THE VILLAS AT CLAREMONT RANCH

PUD DEVELOPMENT PLAN & PRELIMINARY PLAN

PUD & PRELIMINARY PLAN

DATE: 9/17/21 BY: JS DESCRIPTION: County Comments

ROAD CROSS SECTIONS - PER DEVIATION REQUEST

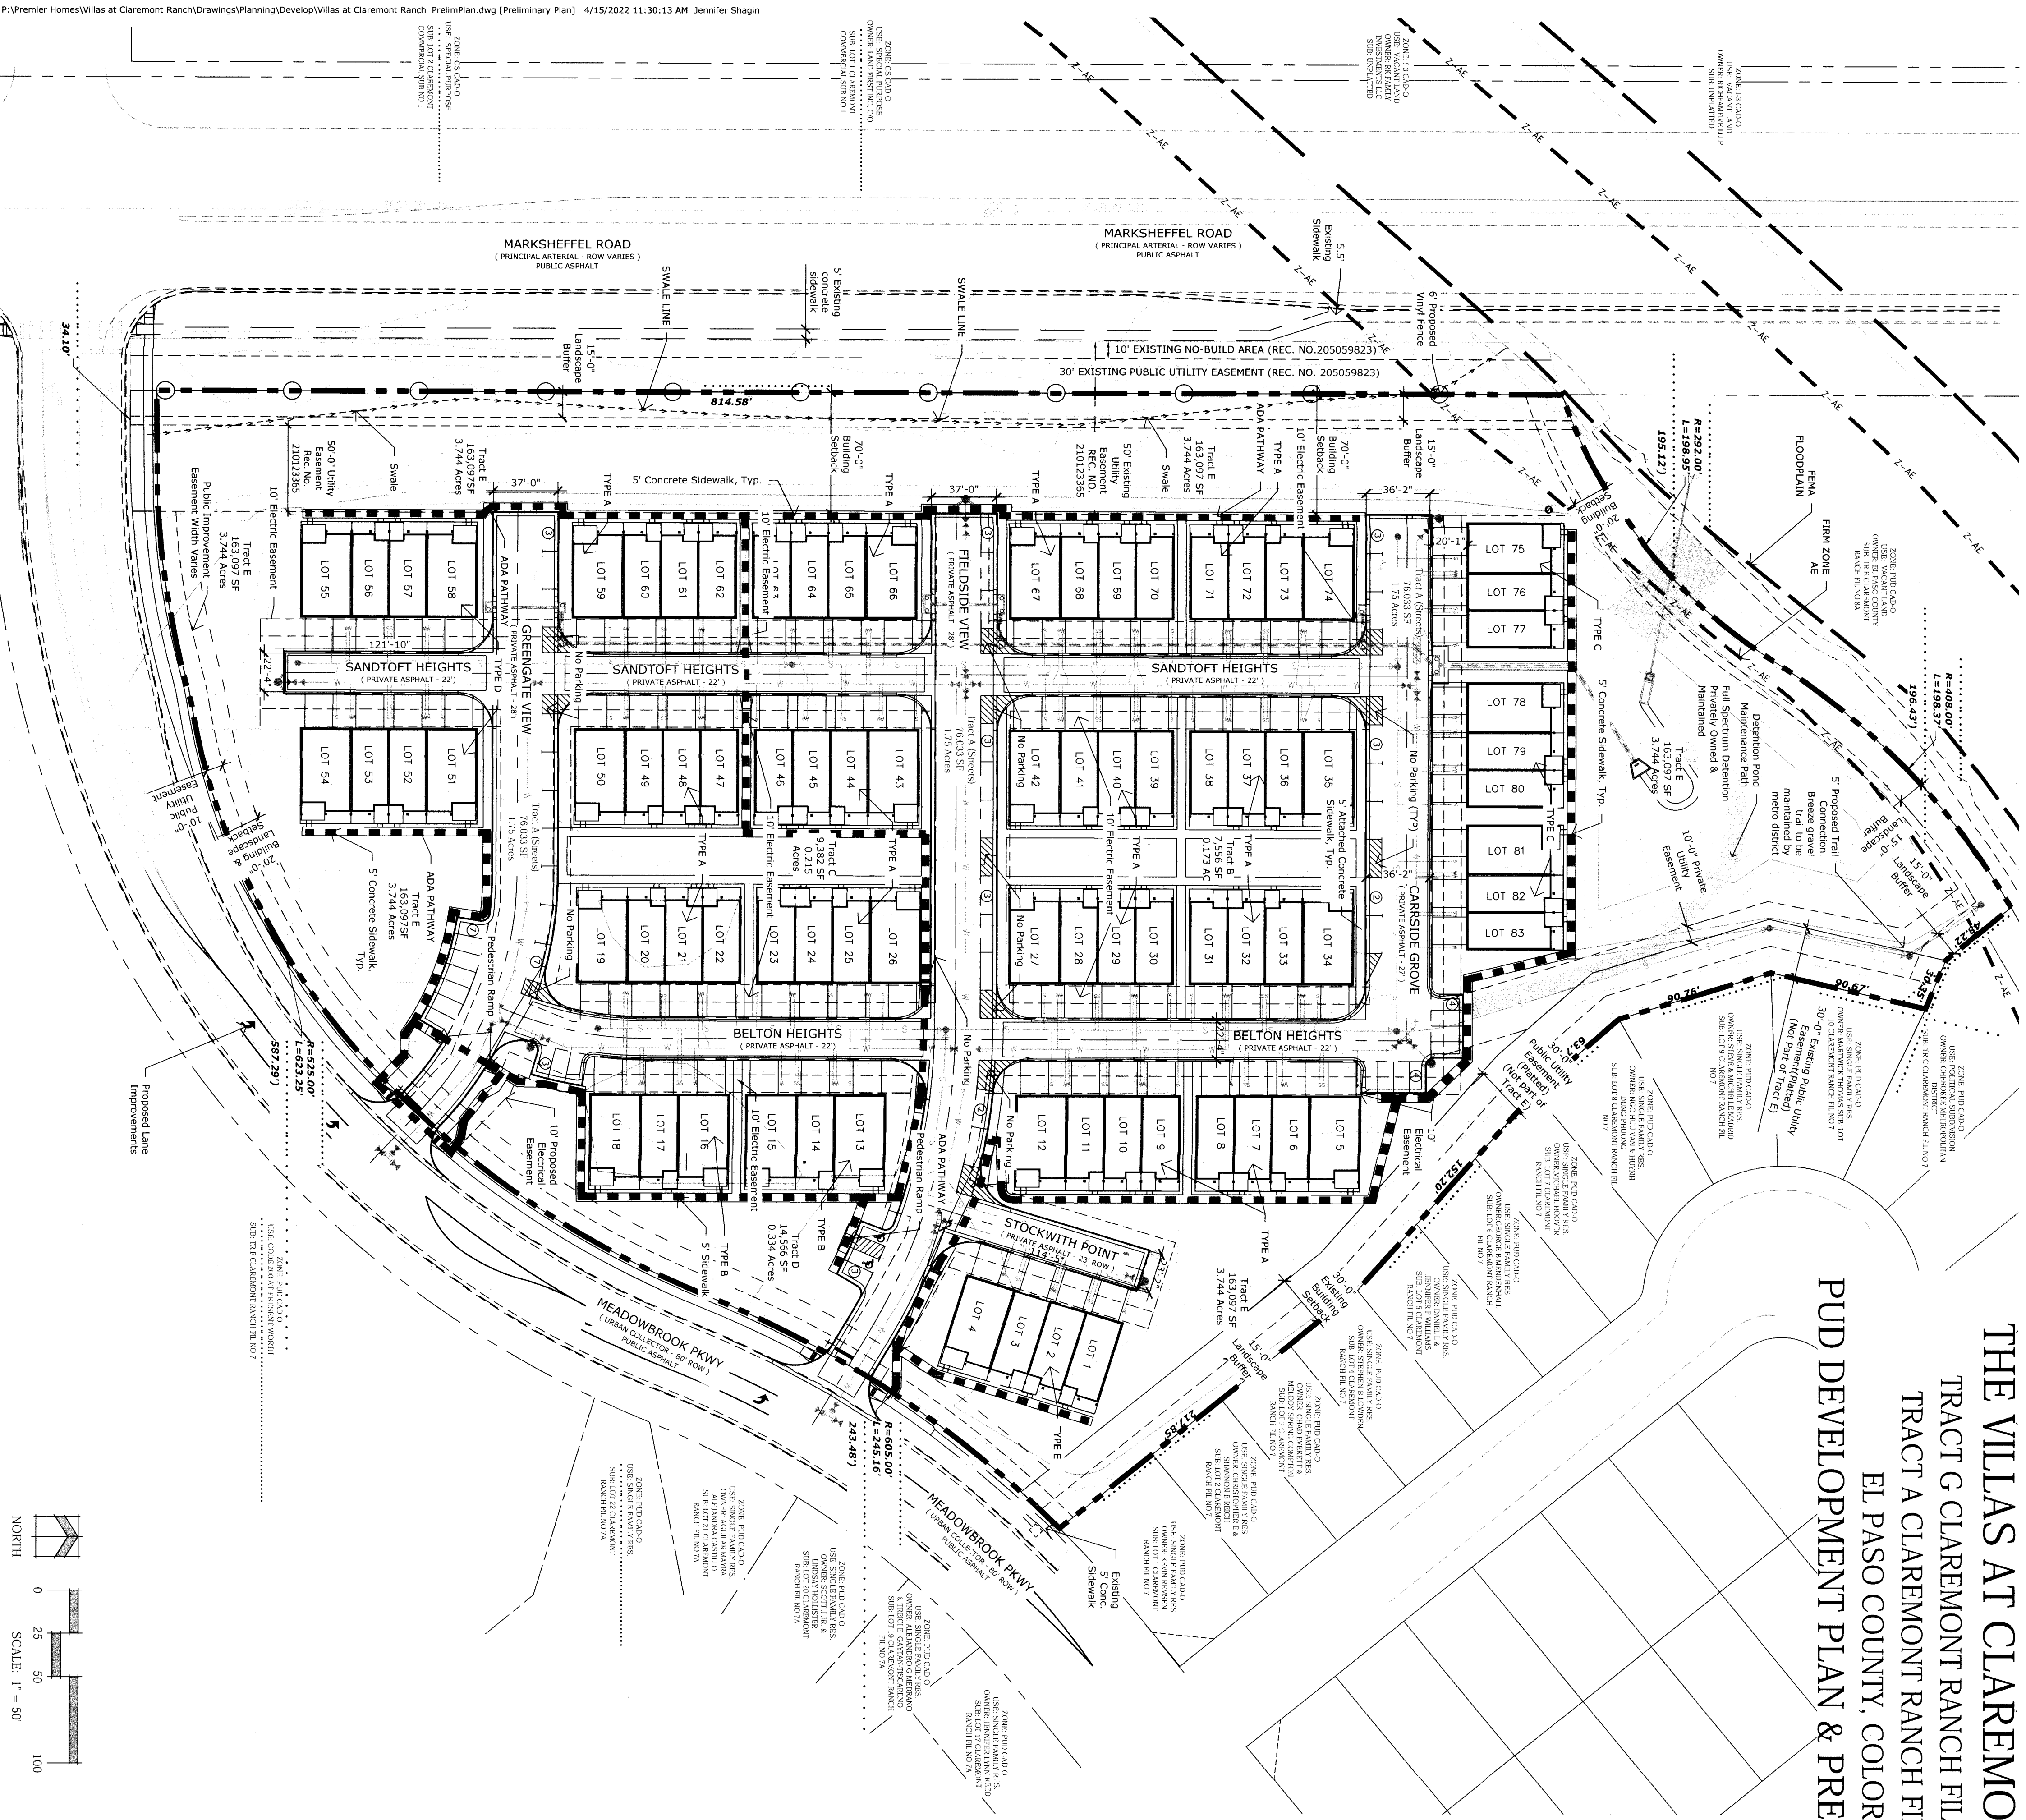
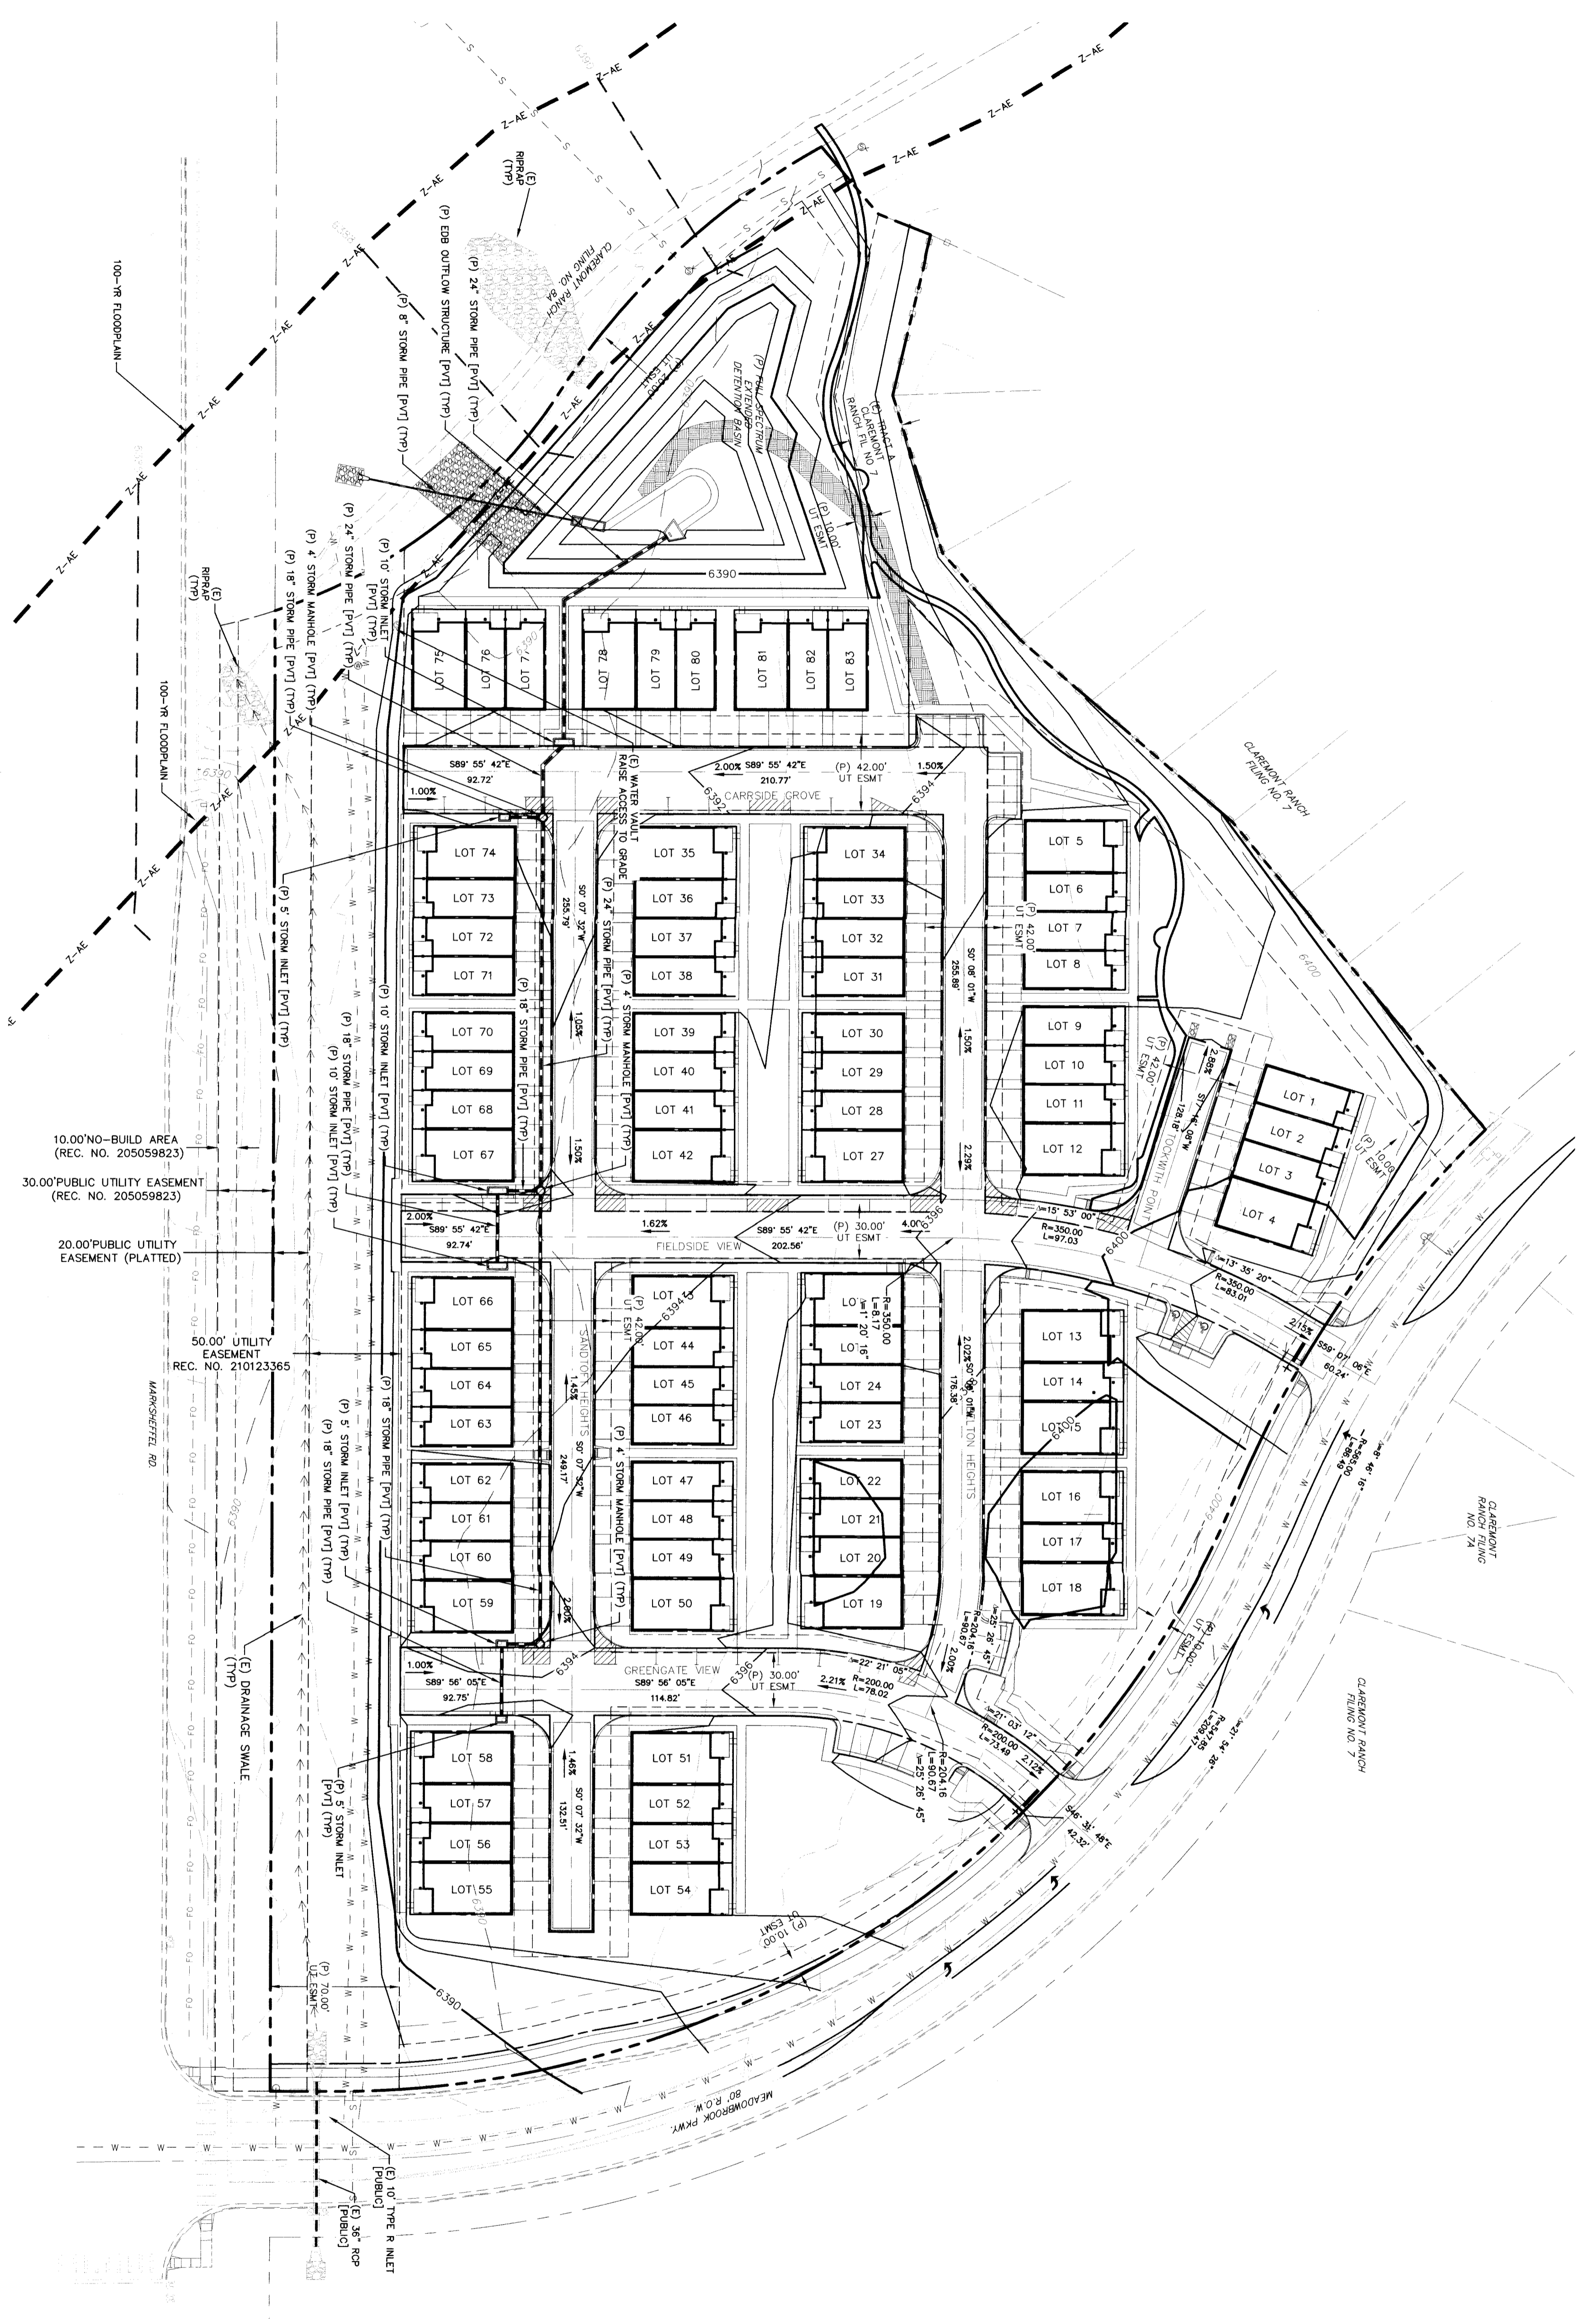
Show ADA path through site

Provide all checklist items including previous redlines on Sheet 3

Show and label ditch

Will sidewalk construction on this grate meet ADA requirements?
